Application for Planning Permission for Works or Extension to a Dwelling

Development Remove the existing conservatory & form new garden room, form new extensions to bedroom 3 & dressing room to master bedroom. Extend the width of the existing garage and connect roofs all as shown on the attached drawings.

Location 7 Kingsmead Gardens Bognor Regis

I regret that I am unable to accept your documents as a formal application until the following matters have been resolved :-

Location Plan

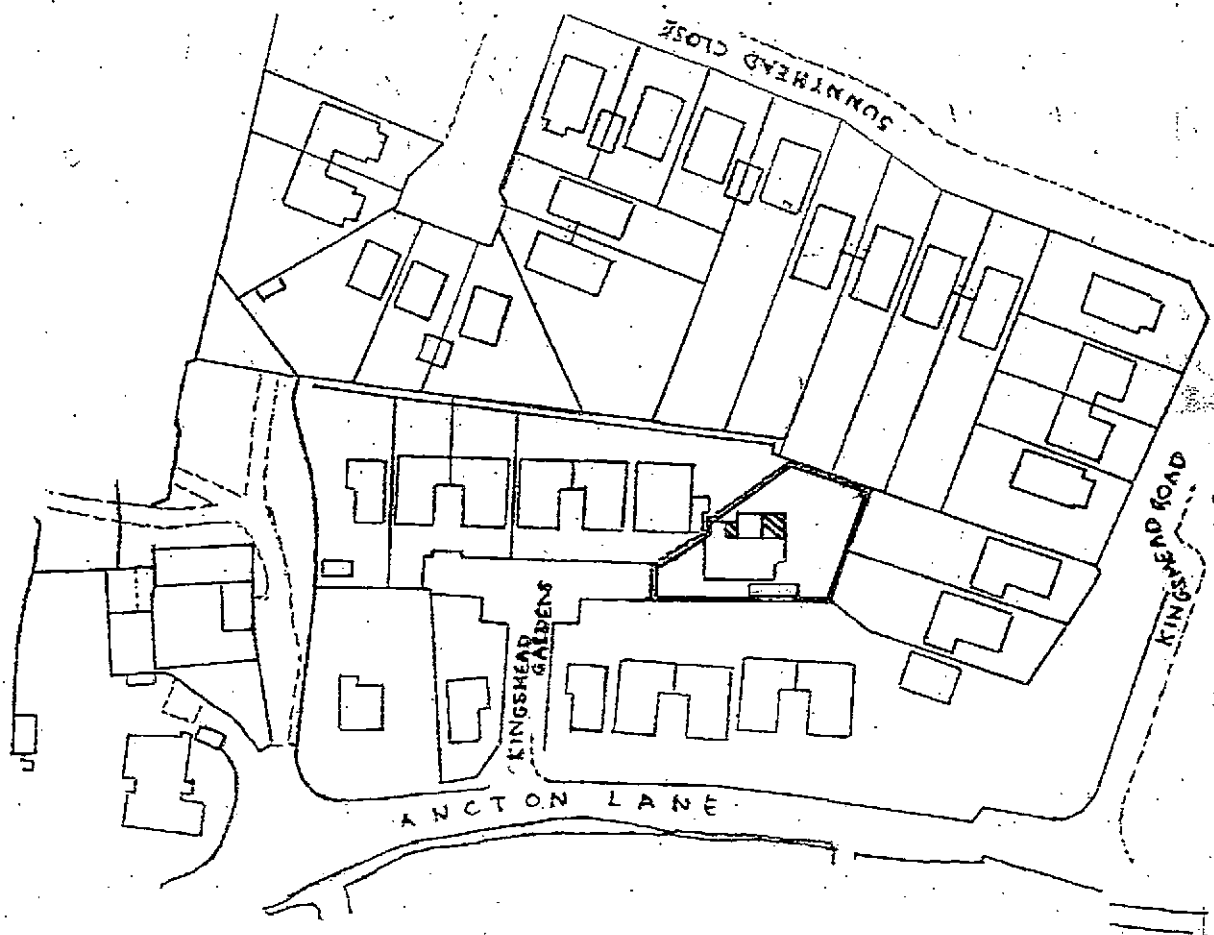
I require 1 electronic or 3 paper copies of a revised location plan with the site clearly red edged in accordance with the guidance notes available on our website detailed below (click on National List).
